16 March 2016

Subject: One Carrington Street – Response to Section 96 modification comments

drawing **Typical Cladding Detail 3**  
 15mm Deep Fins

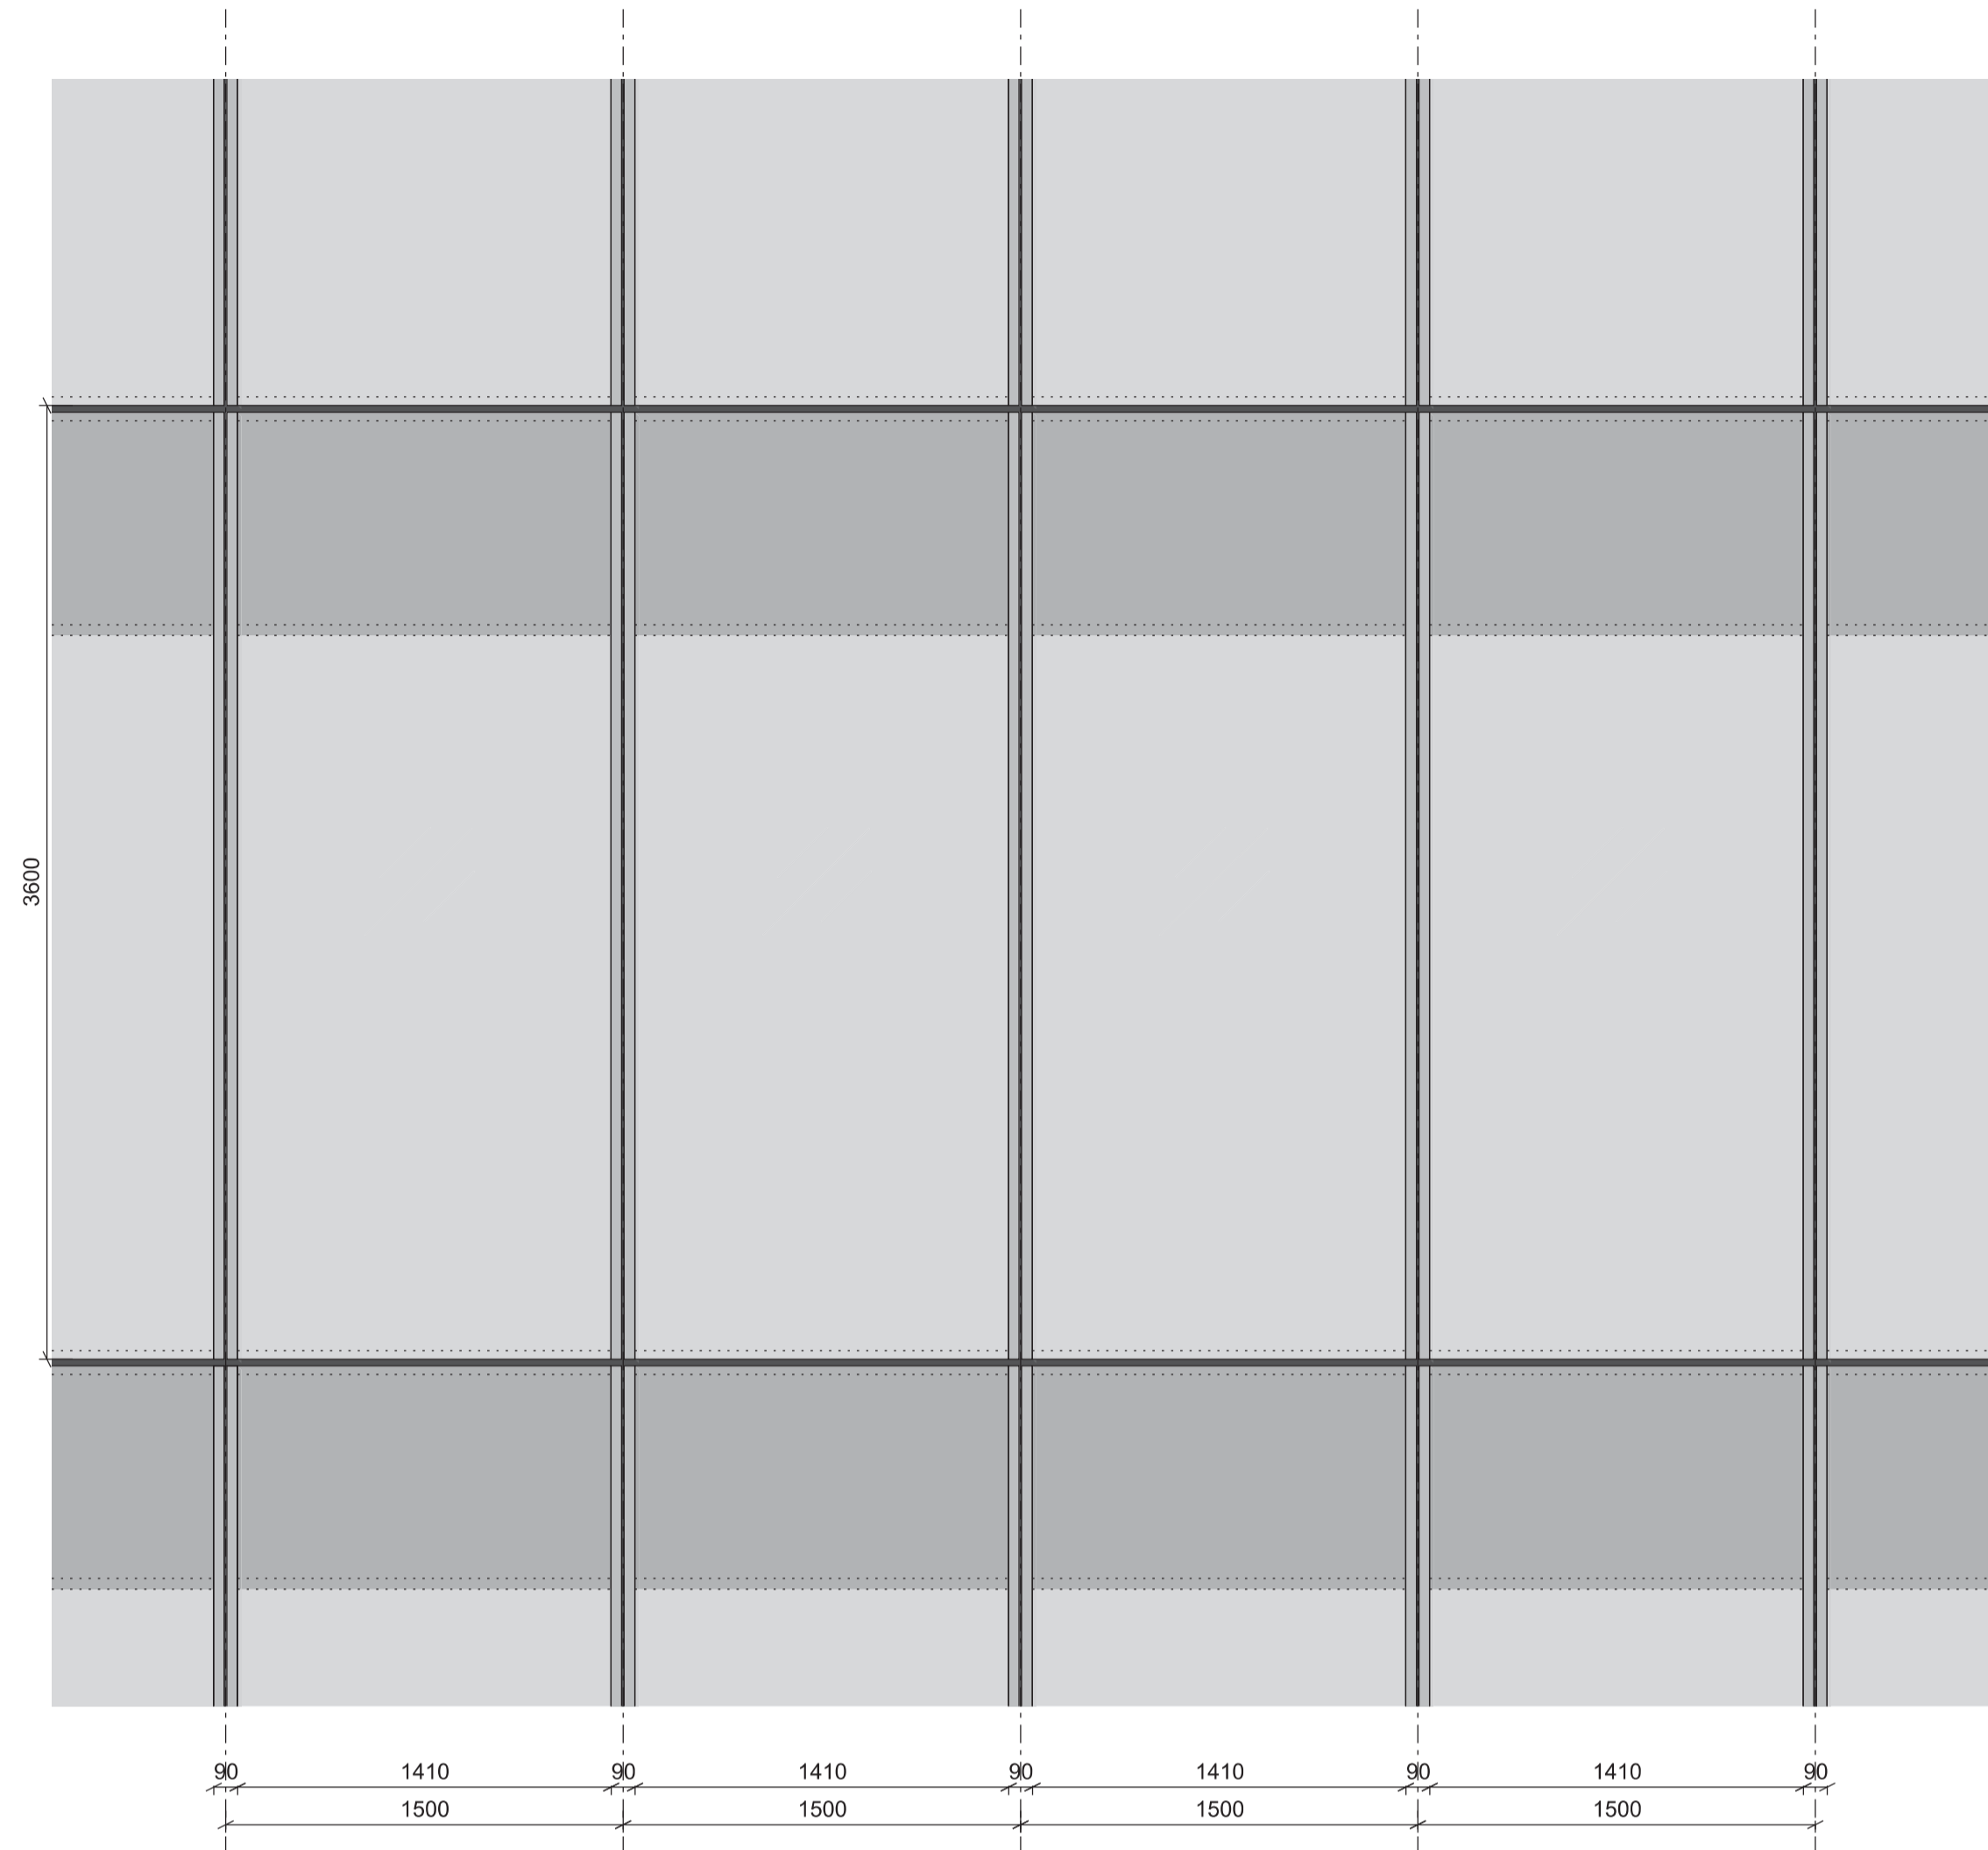
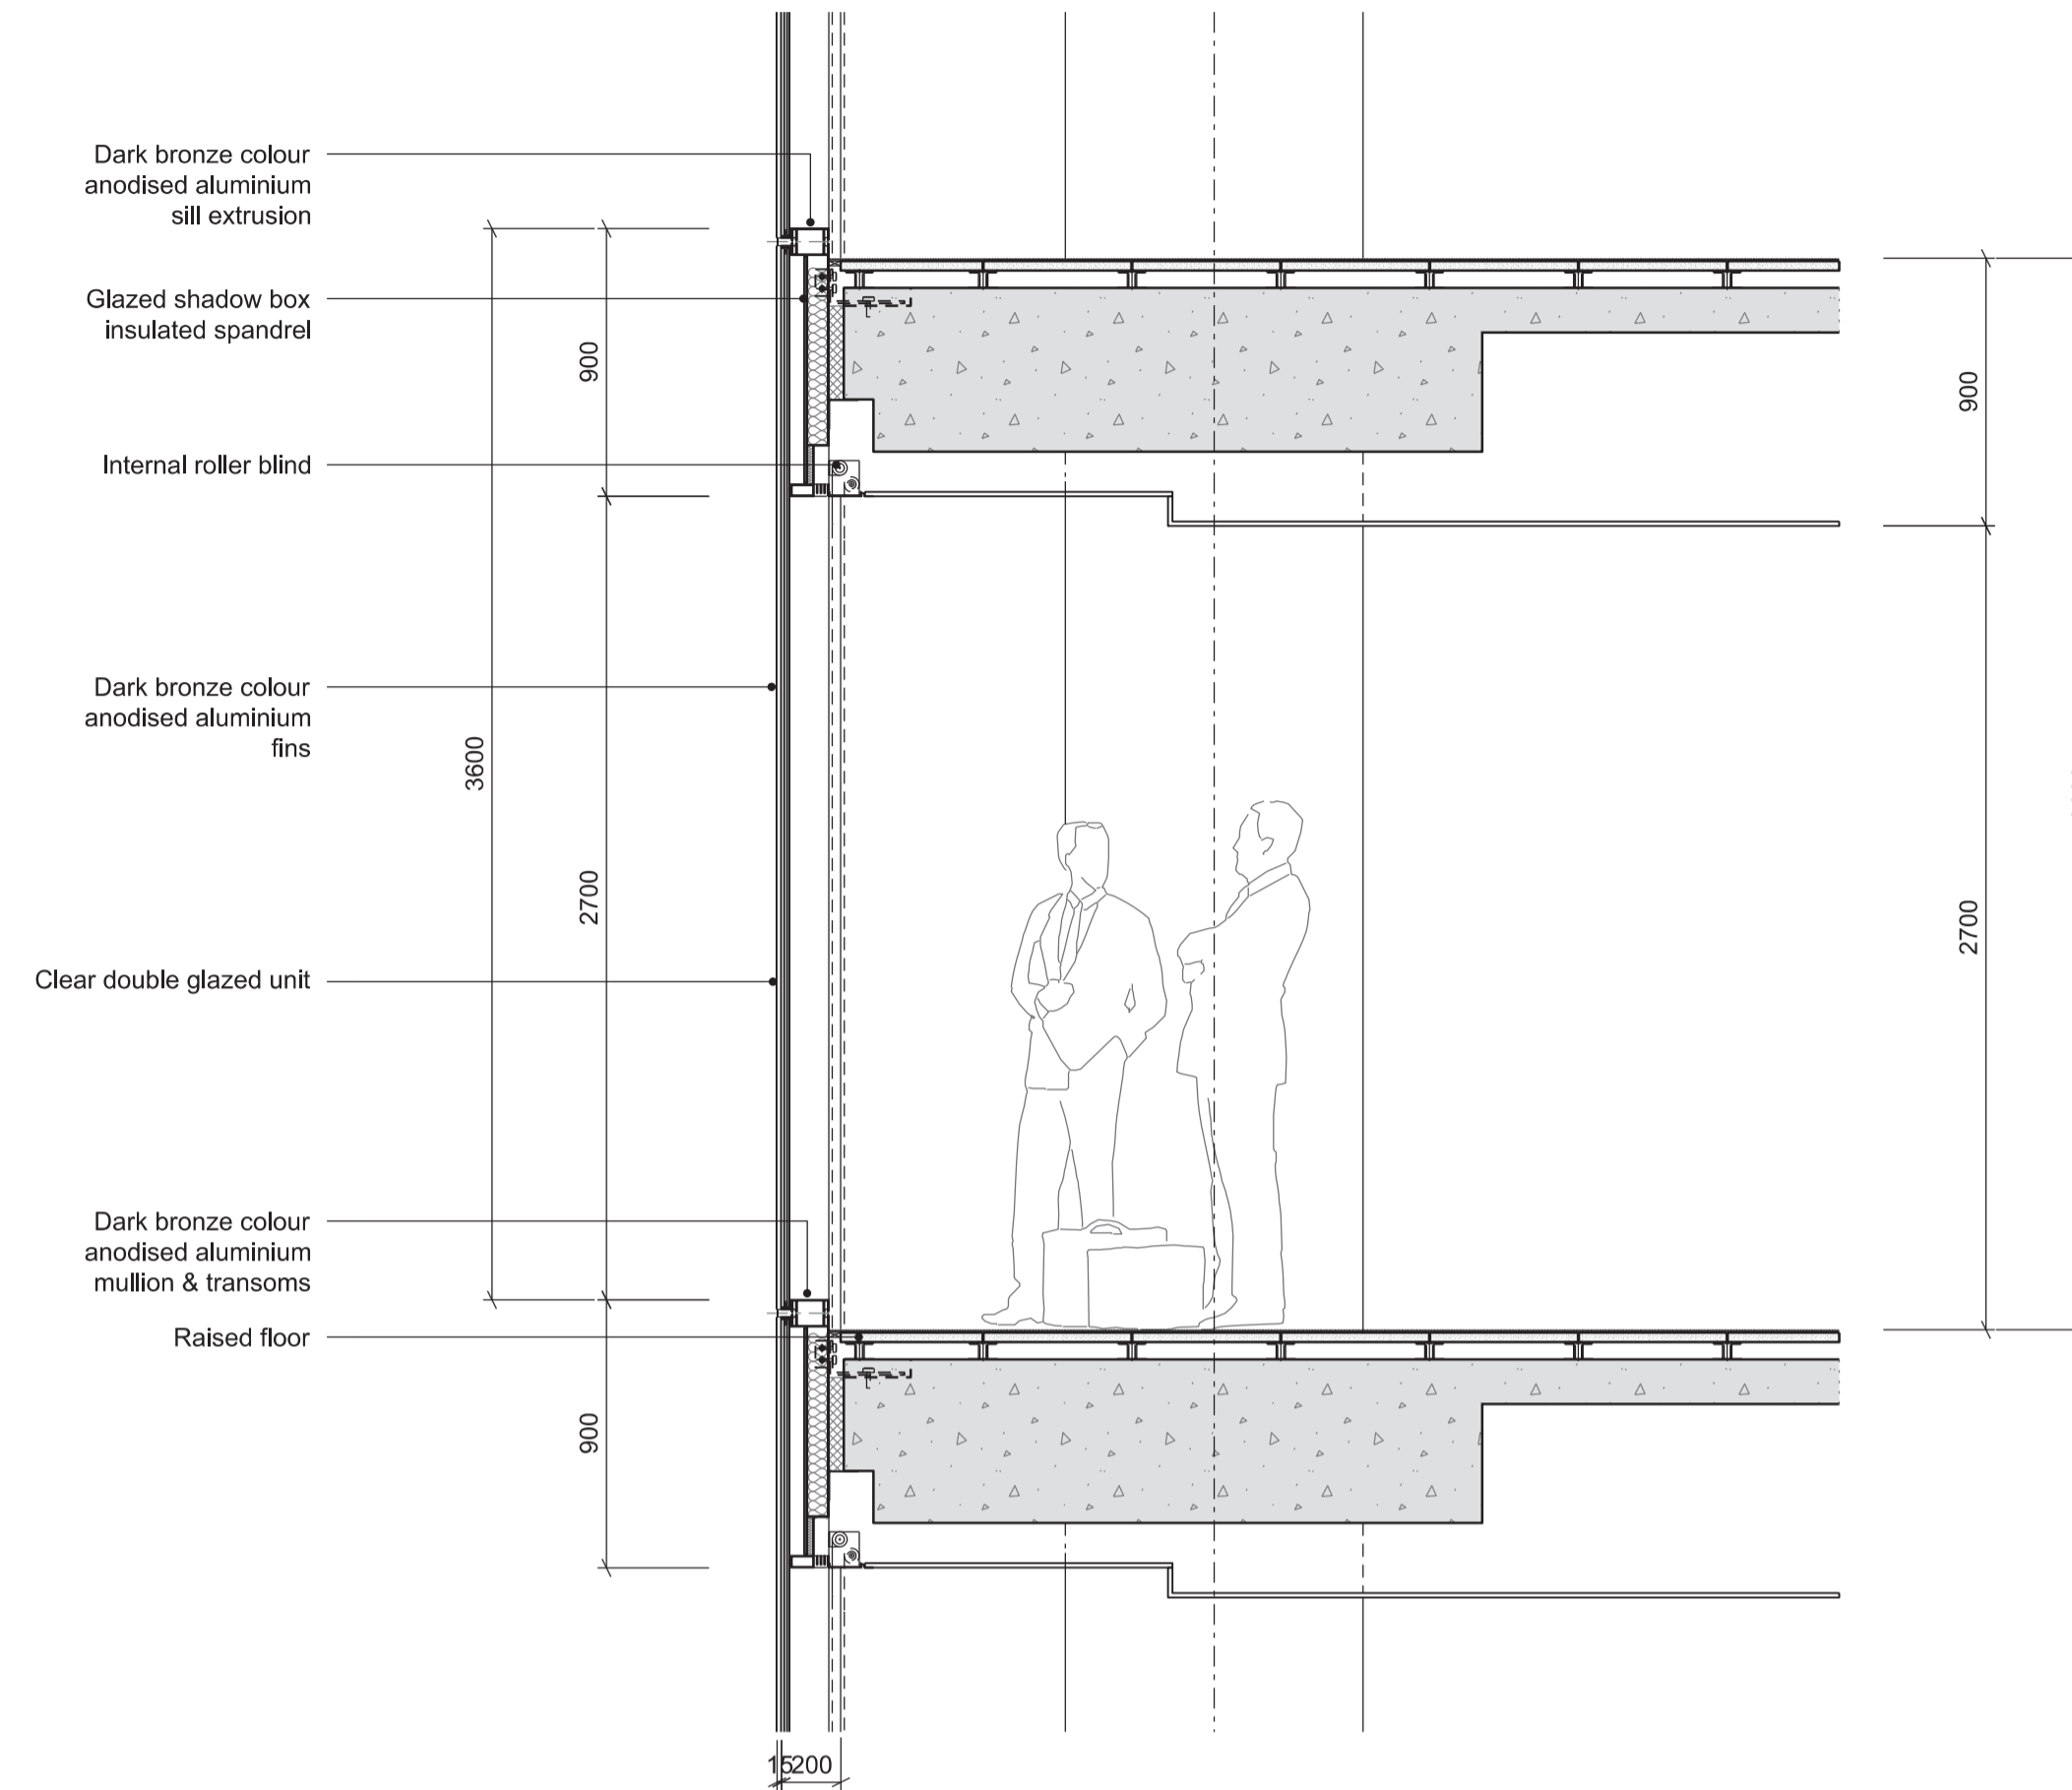
As the Department has pointed out the 15mm capping will not read as a fin, however, as illustrated in the renders, the 15mm does provide fine grain articulation to the facade which ties it in with the overall materiality and architectural expression of the building.

The views demonstrate that the part of the building which the 15mm façade type applies to only presents a slender façade to the primary frontages of Carrington Street and George Street and will therefore always be seen in the context of the other façade types. Its predominant frontage is to the south, however as the views from the public domain illustrate, this frontage will not be viewed front on and is largely obstructed by other buildings. In particular we note that 333 George Street is under construction and will completely obstruct views from street level south of Martin Place.
